From: **Ashwin Muralidharan** Date: **30 Jul. 19** File No: S25504\148\H-121\ca190730s0017 Pages: 2
Project: **Qantas Flight Training & Simulator Centre (Tender No. 9760)** No: **H-004[1.0]**

Hydraulics – Response to Comments on SSDA Submission

This Consultant Advice provides NDY's comments to Agency and stakeholder submissions received during the public exhibition of the SSD 10154 for the development of a new flight training centre at 297 King Street, Mascot.

- A2
- KING ST. TREES AMENDED
 - LANDSCAPE AREAS/TREES ADDED
 - CAR SPACE DELETED
 - RAINWATER TANK ADDED

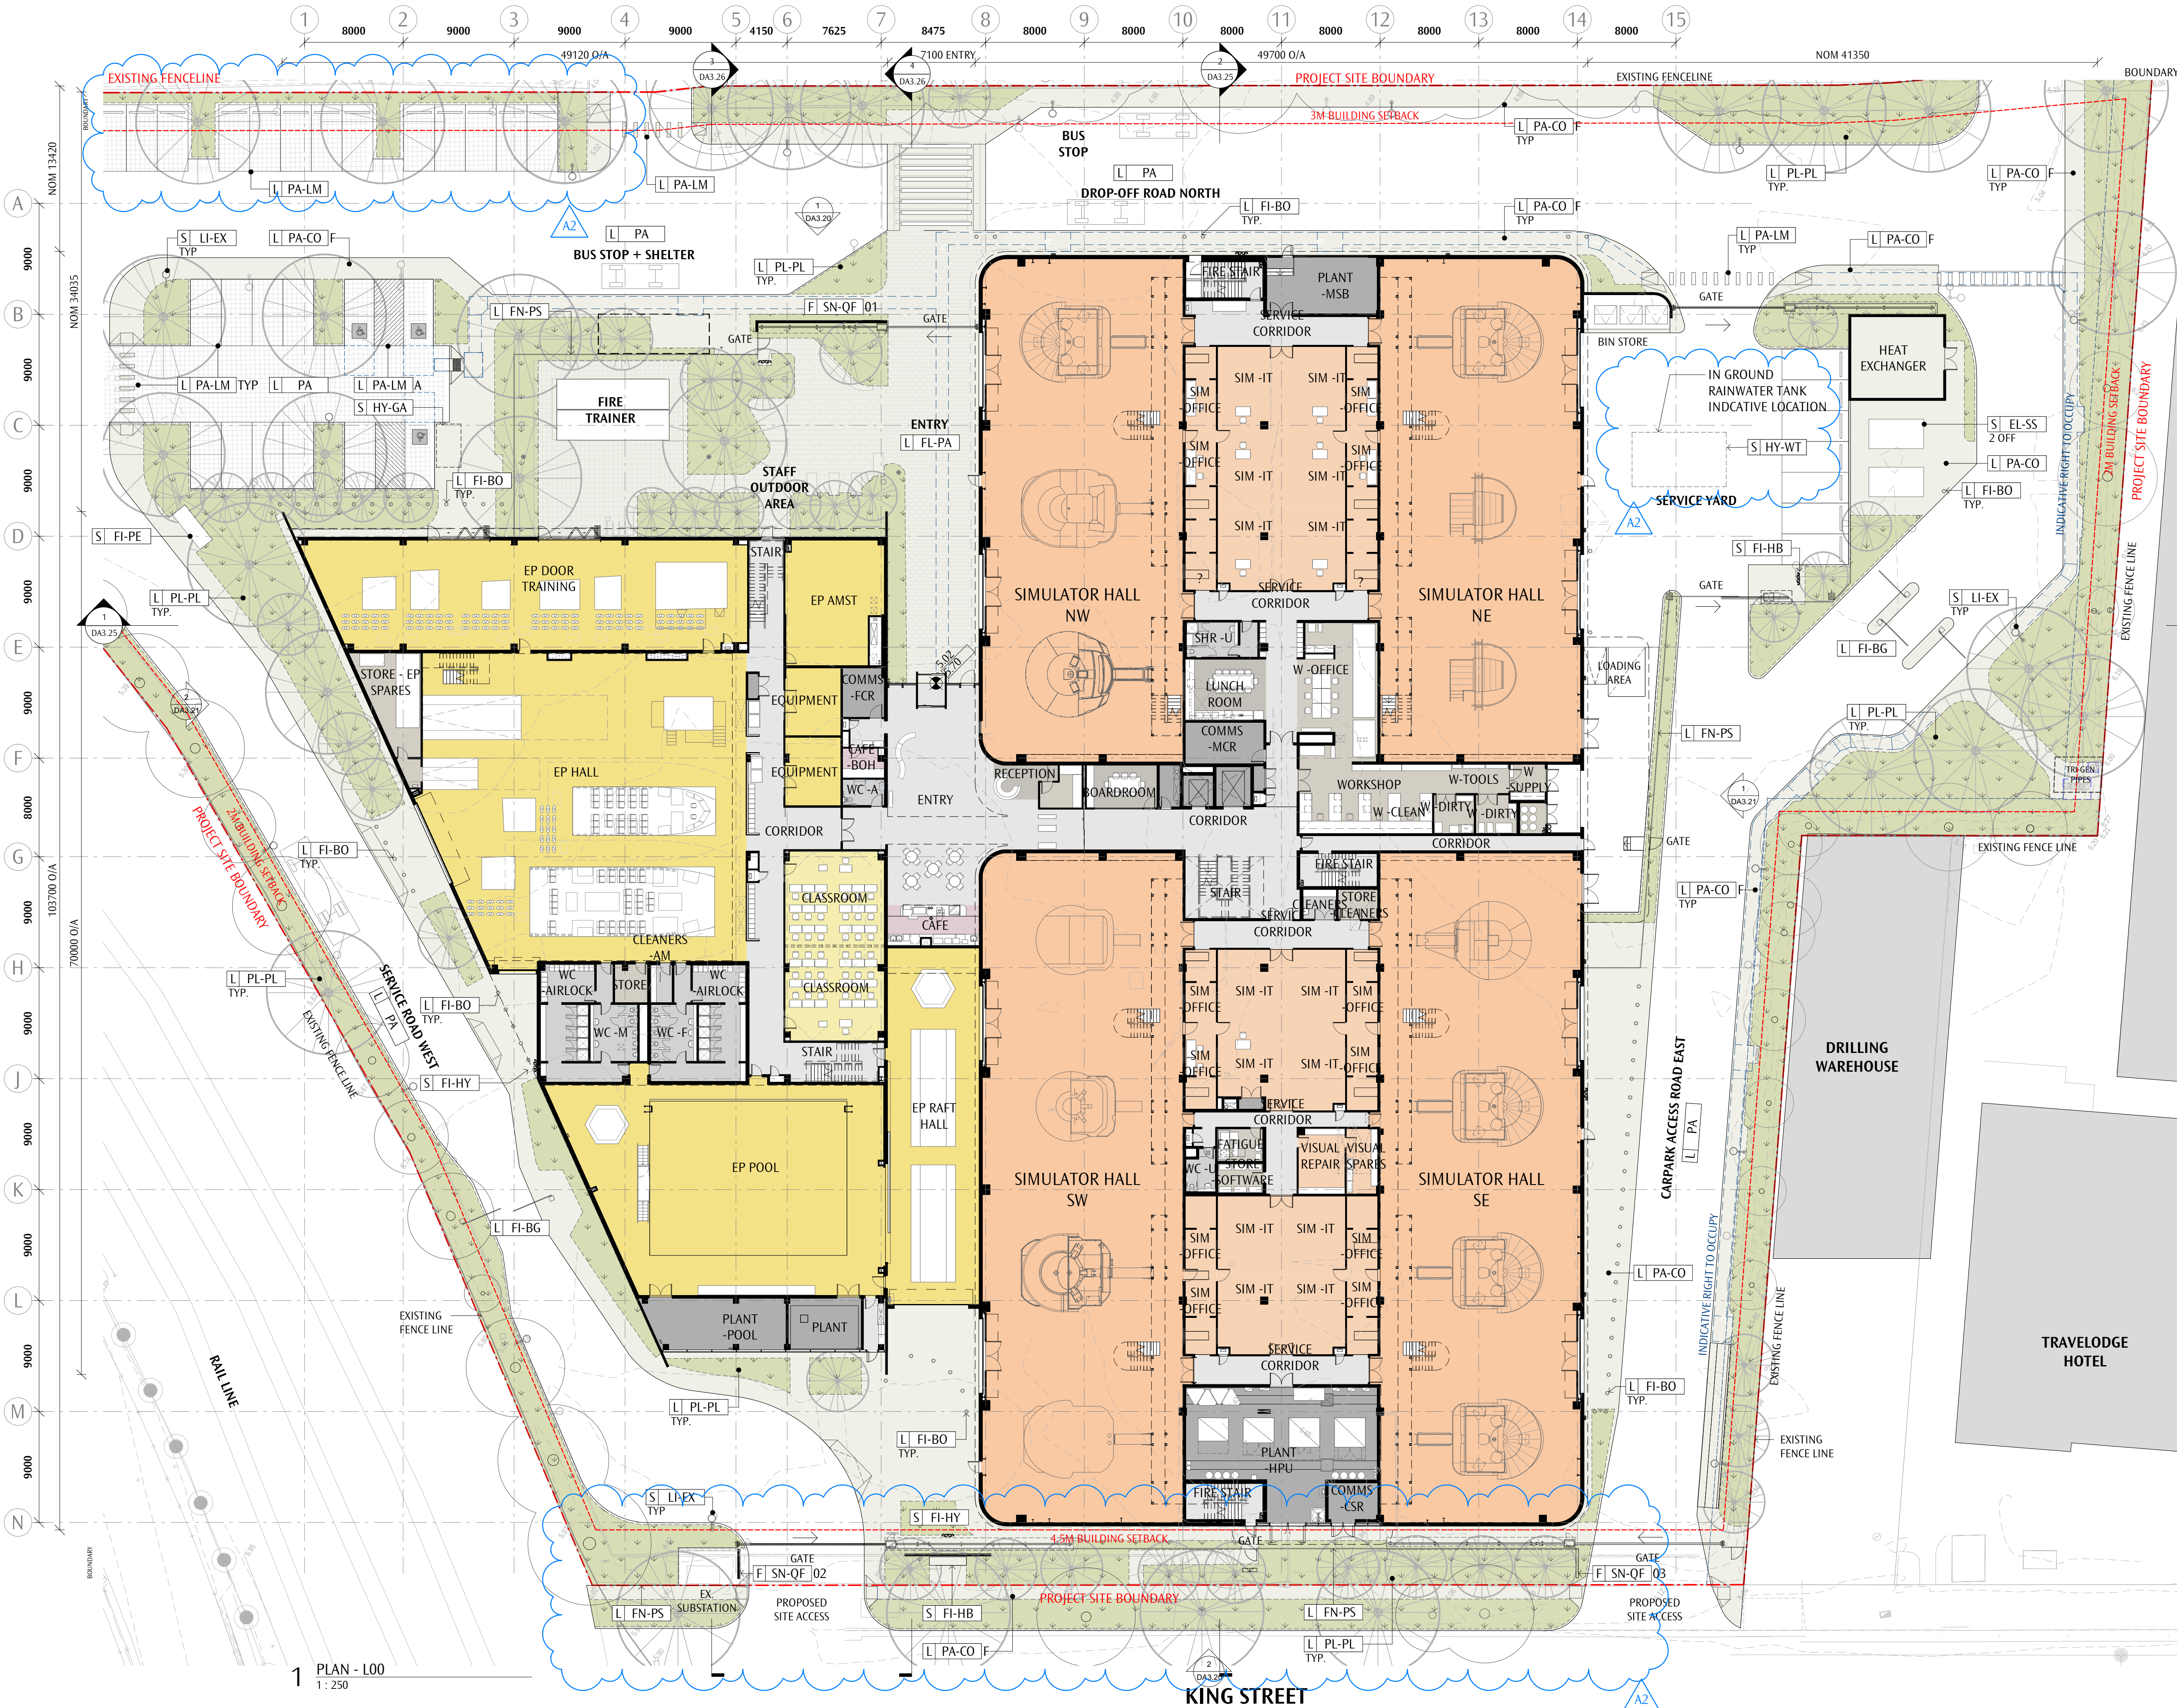
- A minimum 10000 litres capacity of rainwater tank(s) shall be provided for the development as roof areas exceed 5000m2. The rainwater is to be re-used for non- potable uses throughout the development which includes all toilets and landscape irrigation. This is detailed in Botany Bay DCP Part 10 – Stormwater Management Technical Guidelines sec 4.*

A 10,000 litre rainwater tank shall be provided within the proposed development in lieu of the current provision of a 2,000 litre rainwater tank. The non-potable water (recycled rainwater) shall be filtered and reticulated within the building for toilet flushing and irrigation.
